Town & Country Planning Act 1990 (as amended)
Town and Country Planning (Development Management Procedure) (England) Order 2015
Approval of details reserved by condition imposed under R/269/15/PL relating to condition 11-
surface water drainage.
Fleur De Lis Station Road, Rustington,

Decision:

Arun District Council have decided to **REFUSE** details reserved by condition for the following reasons:

Drawing Title
DRAINAGE LAYOUT

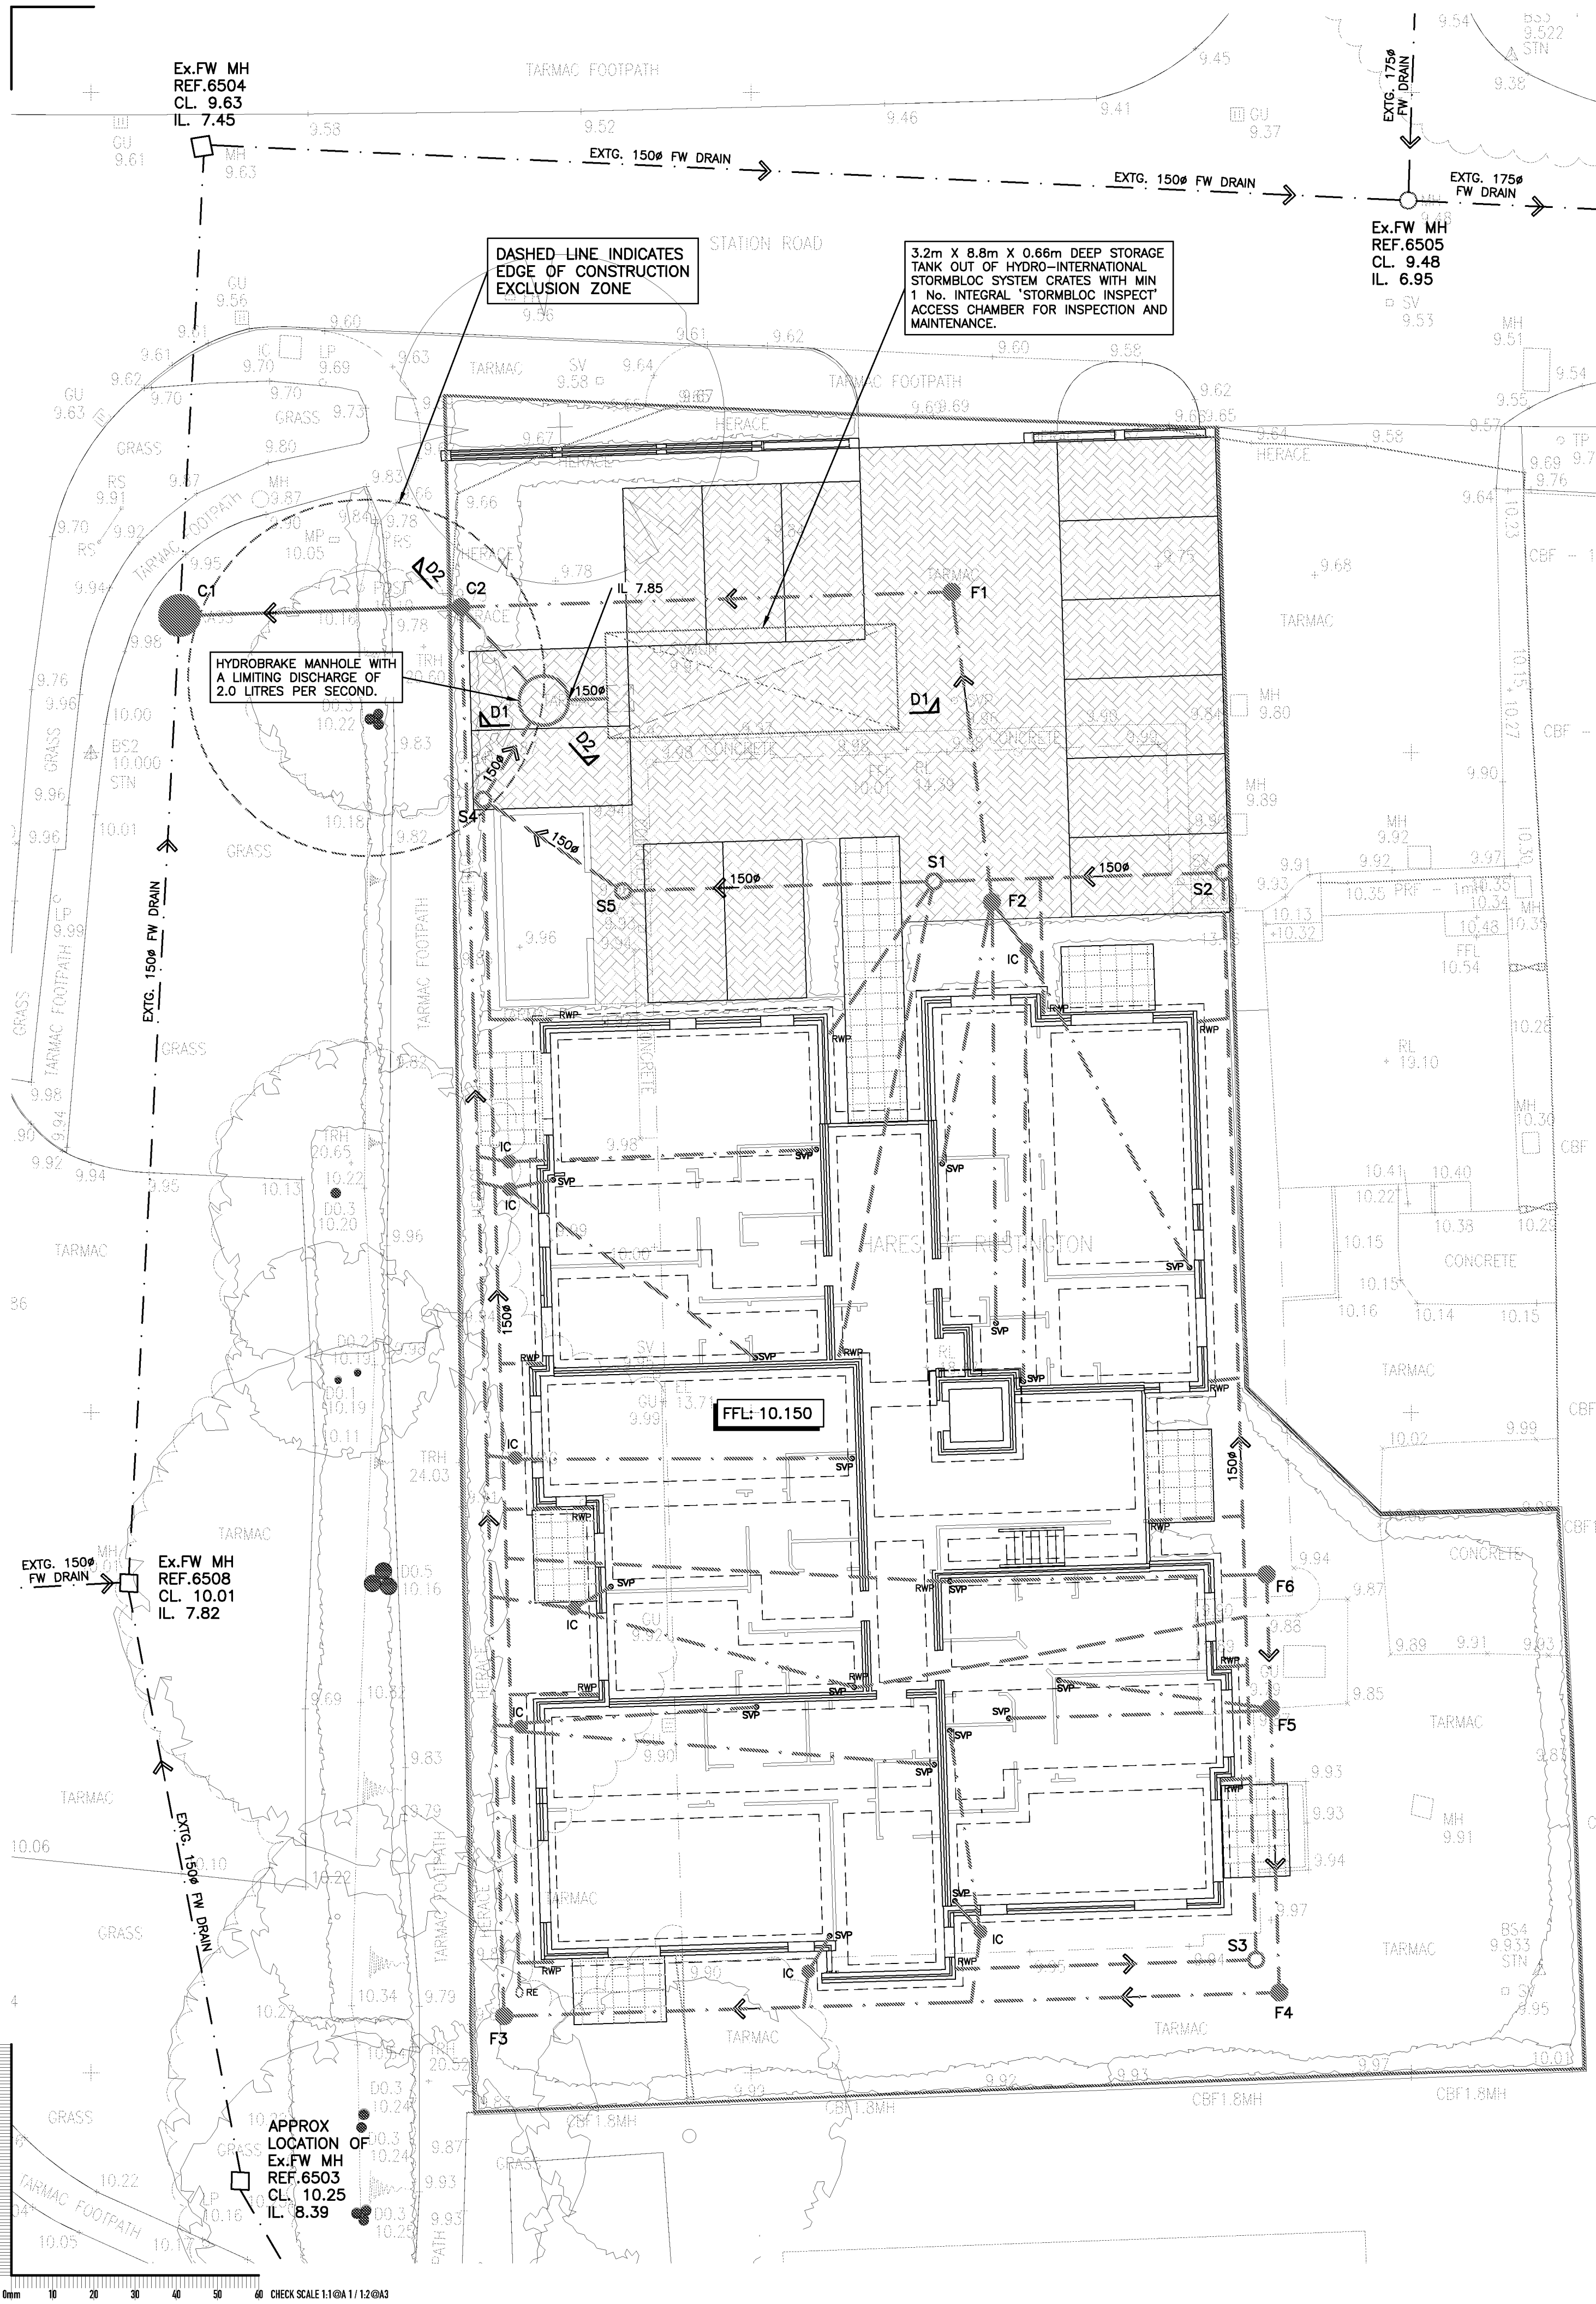
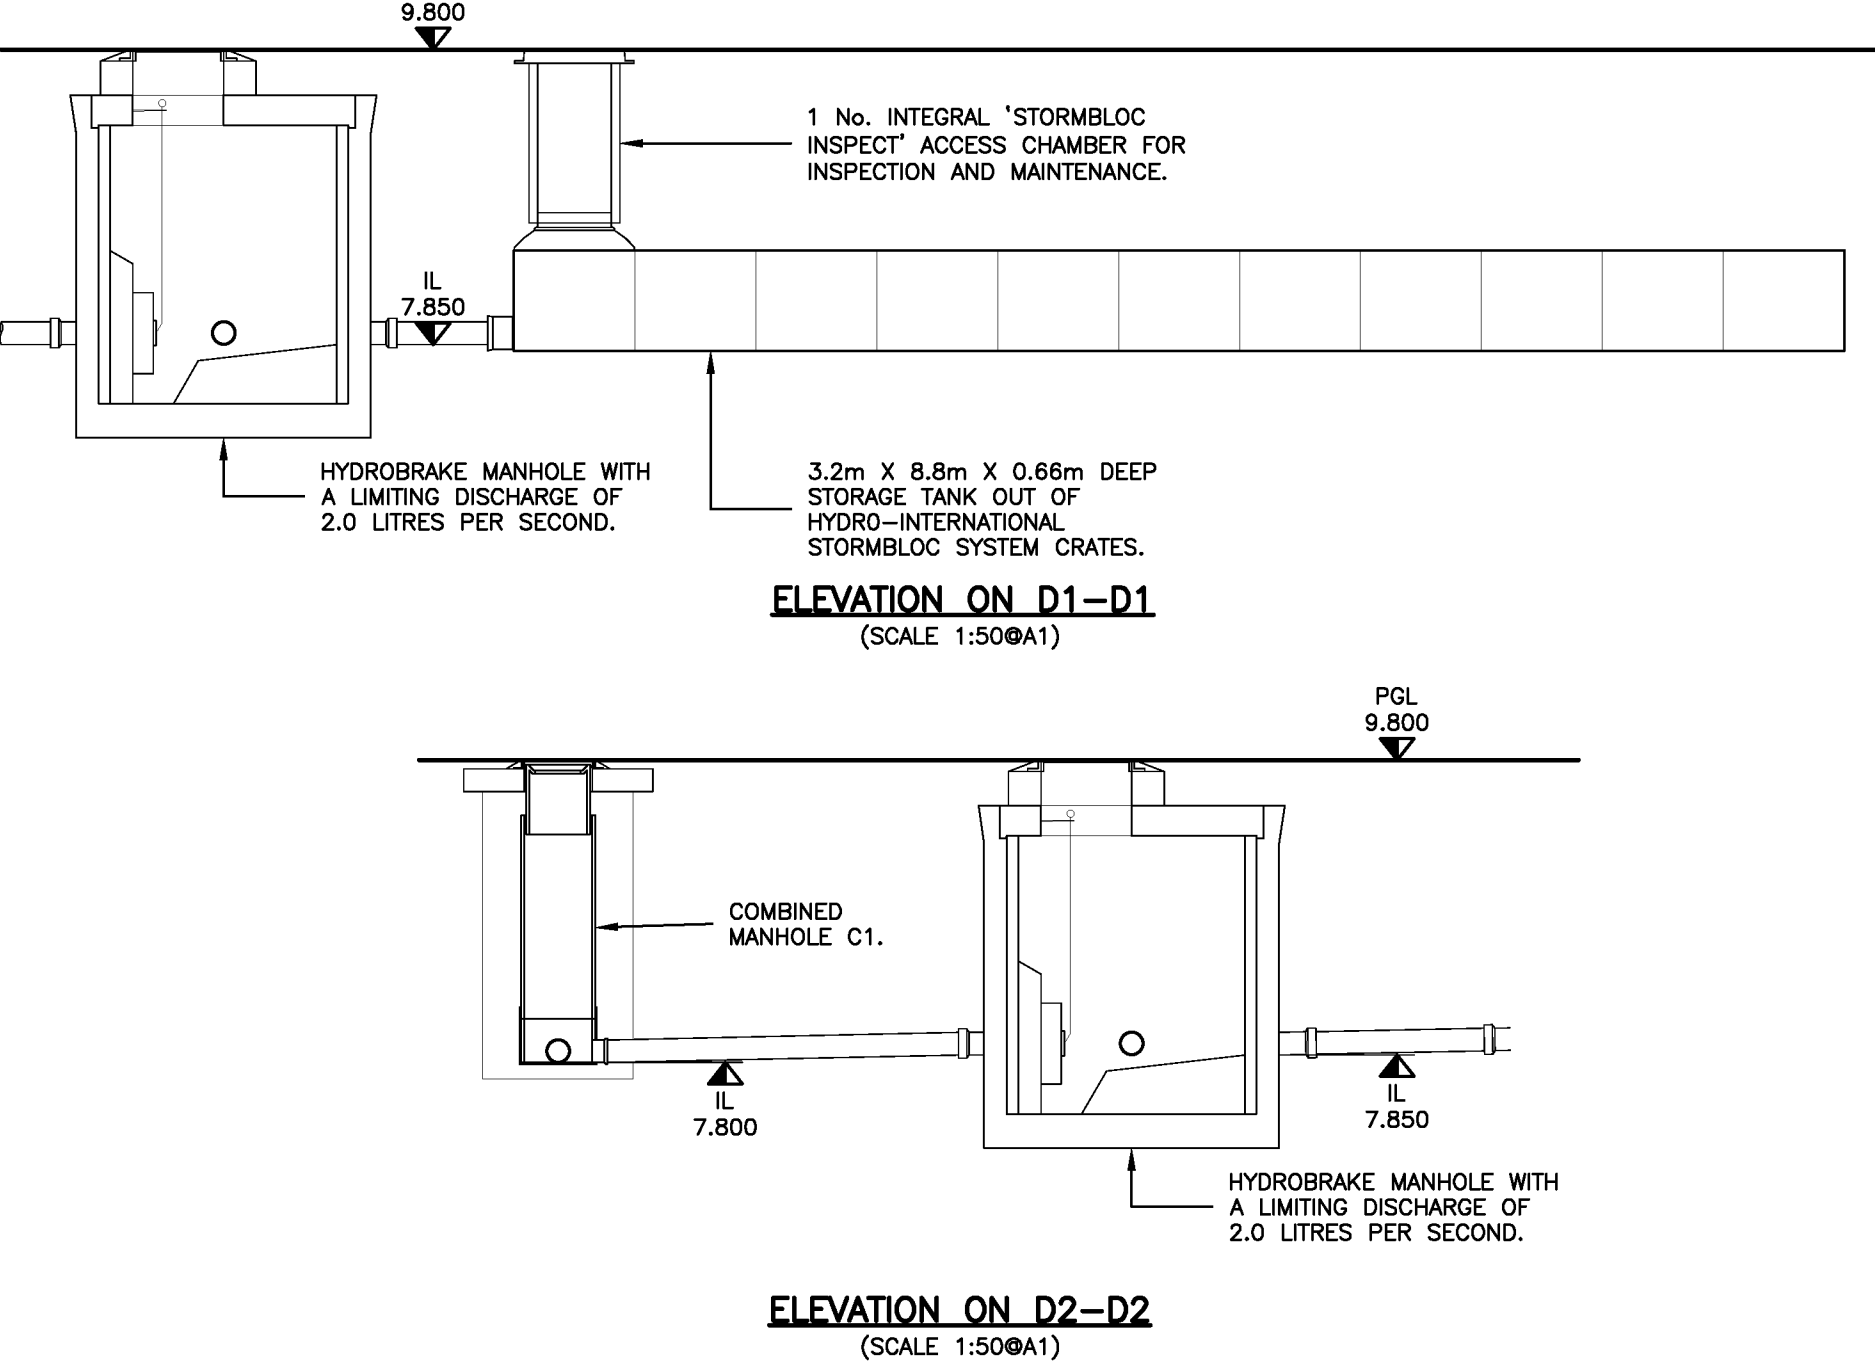
The groundwater monitoring and infiltration tests supplied support the use of shallow infiltration. Permeable paving is specified however, this is only to drain the paved areas themselves. The following should be provided

- Infiltration testing completed in the winter.
- Proof that there is insufficient room to take roof water to permeable pavements and therefore demonstrate the need for attenuation and discharge to foul.
- Calculations demonstrating that the attenuation and permeable paving is appropriate to contain the 1 in 100 year +cc event.
- Construction details of the permeable paving, please also provide finished and formation docdeci

levels on the plan.

- Construction details of the attenuation tanks which include surround details and cover details.
- Construction detail drawings of manholes.
- Construction detail drawings of pipe bedding and surround.
- Connection agreements from southern water.
